**Application by Port of Tilbury London Limited for an Order Granting Development Consent for a Proposed Port Terminal at the Former Tilbury Power Station ('Tilbury2')**

**Deadline 2**

**Highways England Response to Essex County Council's Response to First Written Questions**

Drawing Title: **GENERAL ARRANGEMENT PLANS ASDA ROUNDABOUT SHEET 5 OF 5 REGULATION 5(2)(o)**

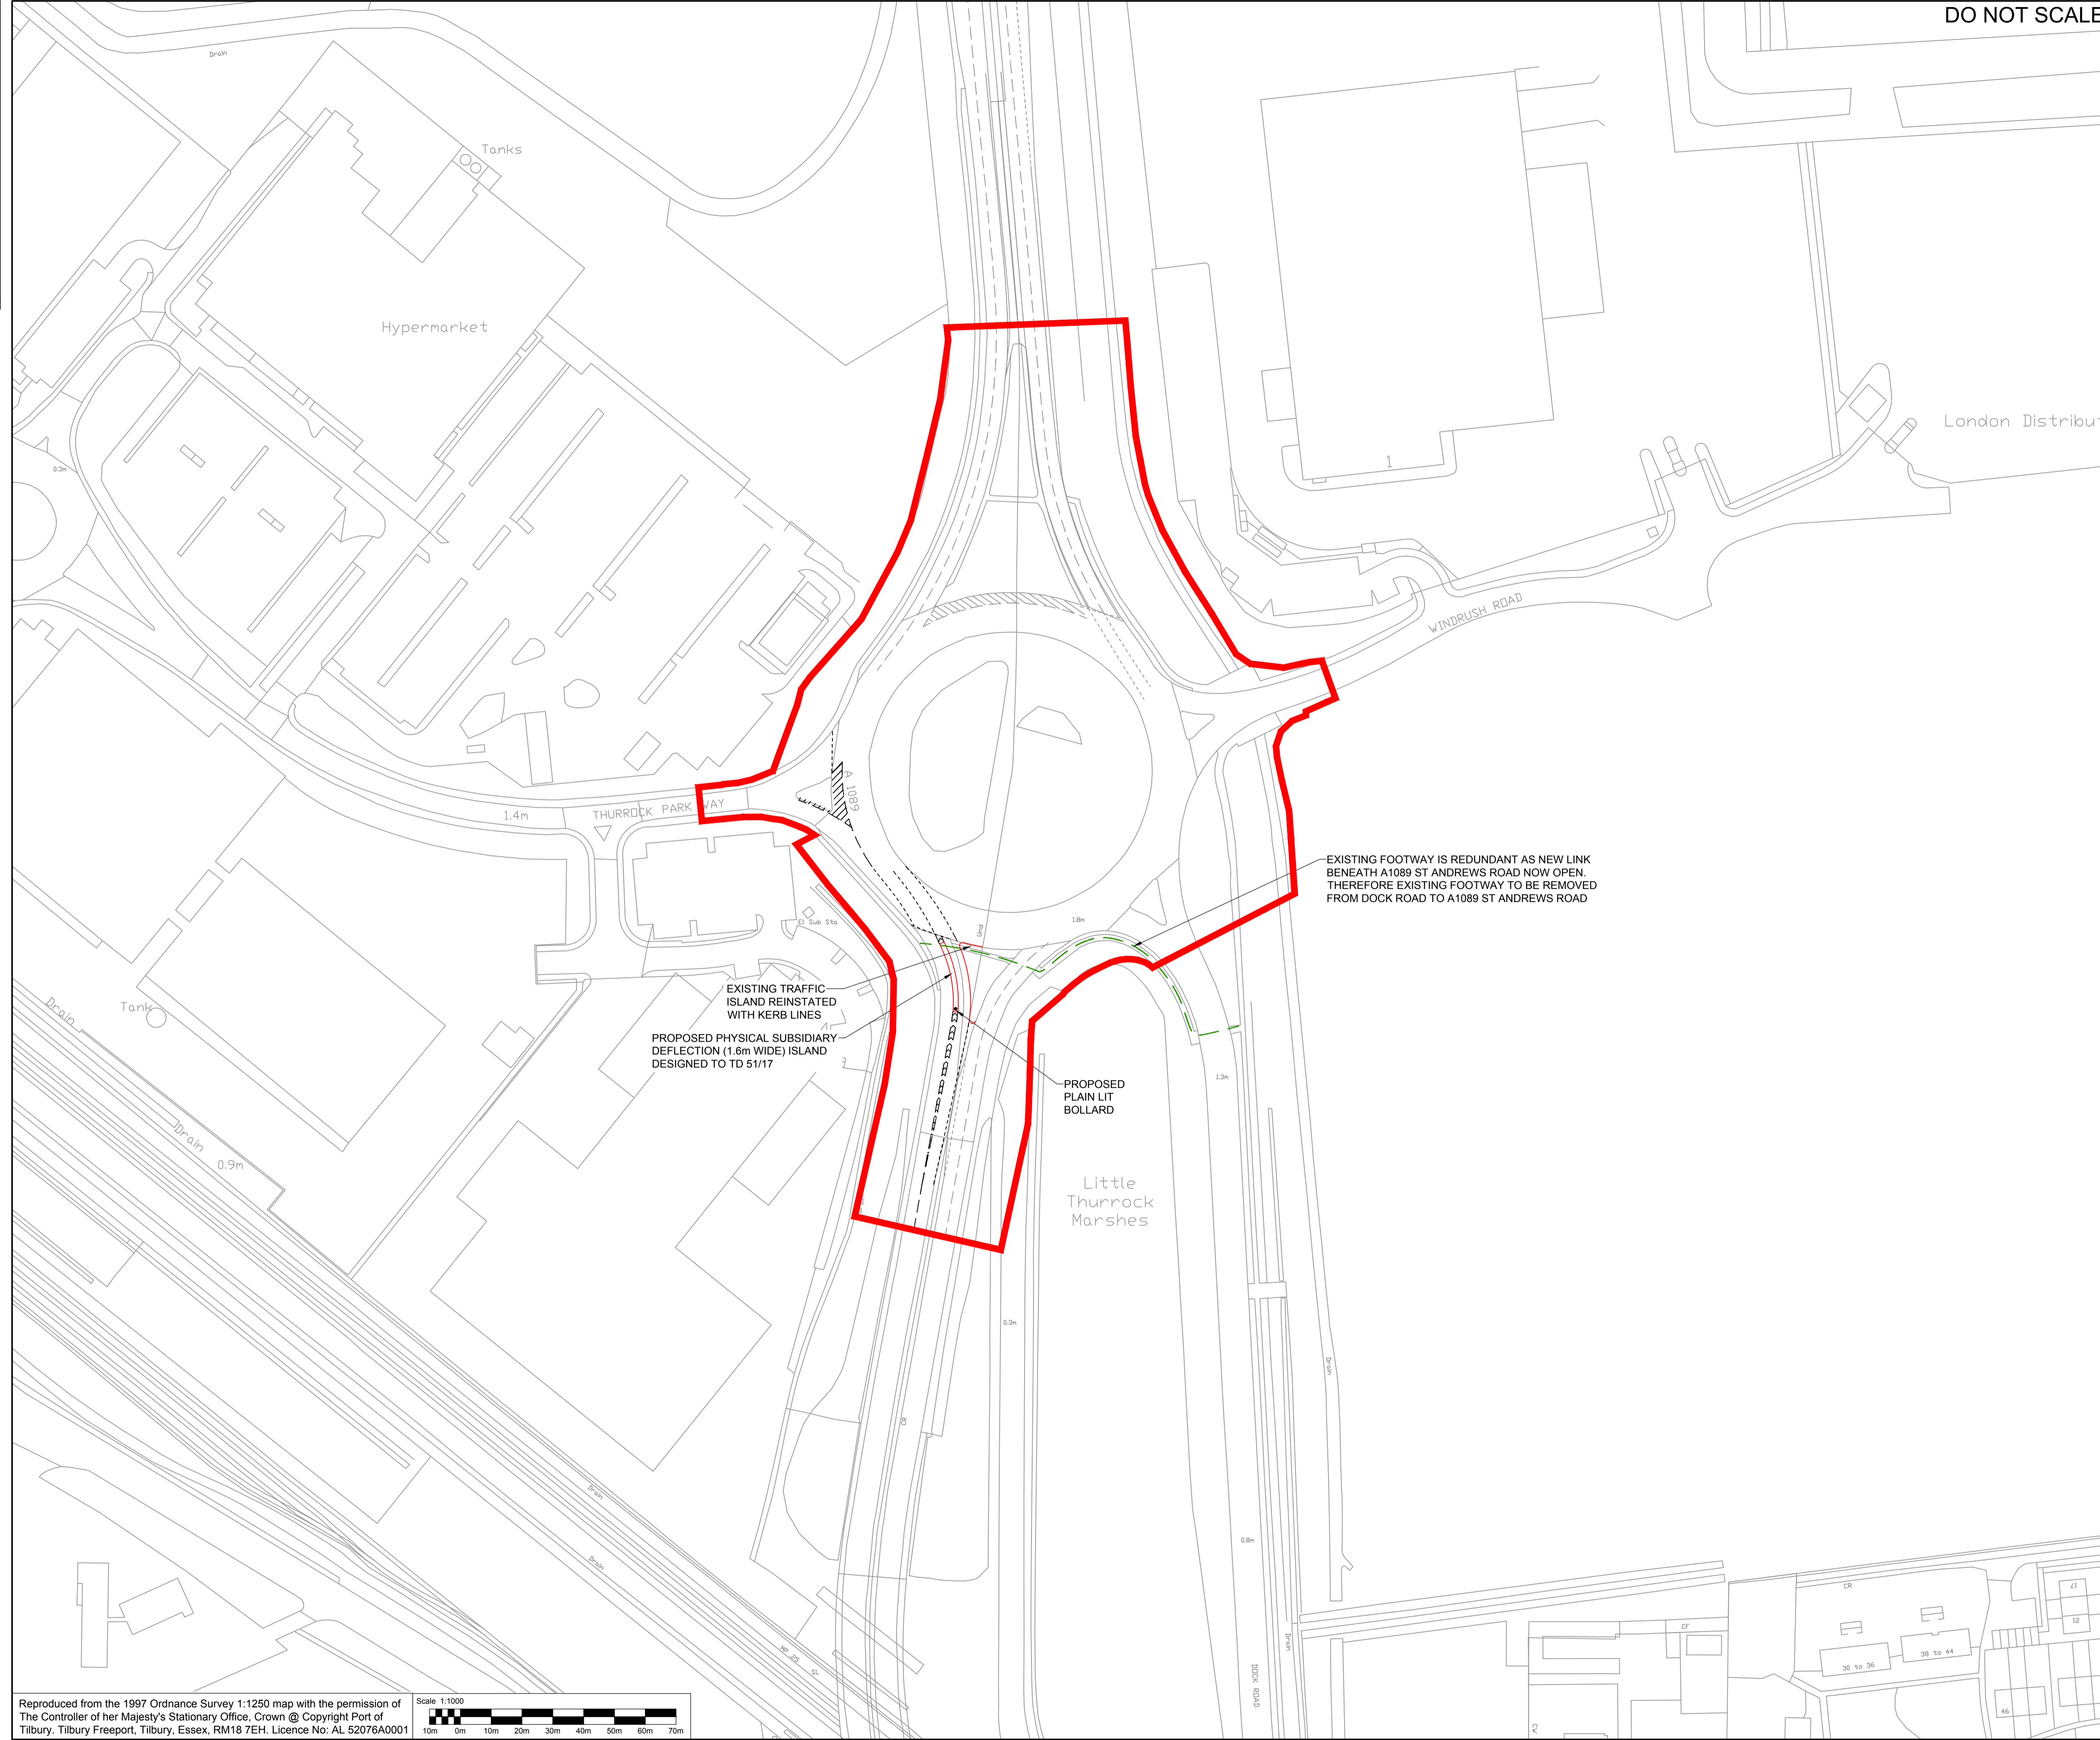
indicate that the approach from the docks may experience congestion which may have a knock on effect on the local road network from Tilbury and ASDA. ECC acknowledges that mitigation for this junction is being developed.

ASDA roundabout. HE is in discussions with the applicant regarding the Trip Generation that will have a direct bearing on the projected future volumes of traffic. Subject to our concerns being satisfactorily addressed, HE will reach an informed view of the impact on the operation of the Asda Roundabout and the level of mitigation which is required. However, based upon the predicted traffic flows set out in the Transport Assessment, the currently proposed level of mitigation is unacceptable to HE in respect of capacity, safety and the level of provision for non-motorised users.
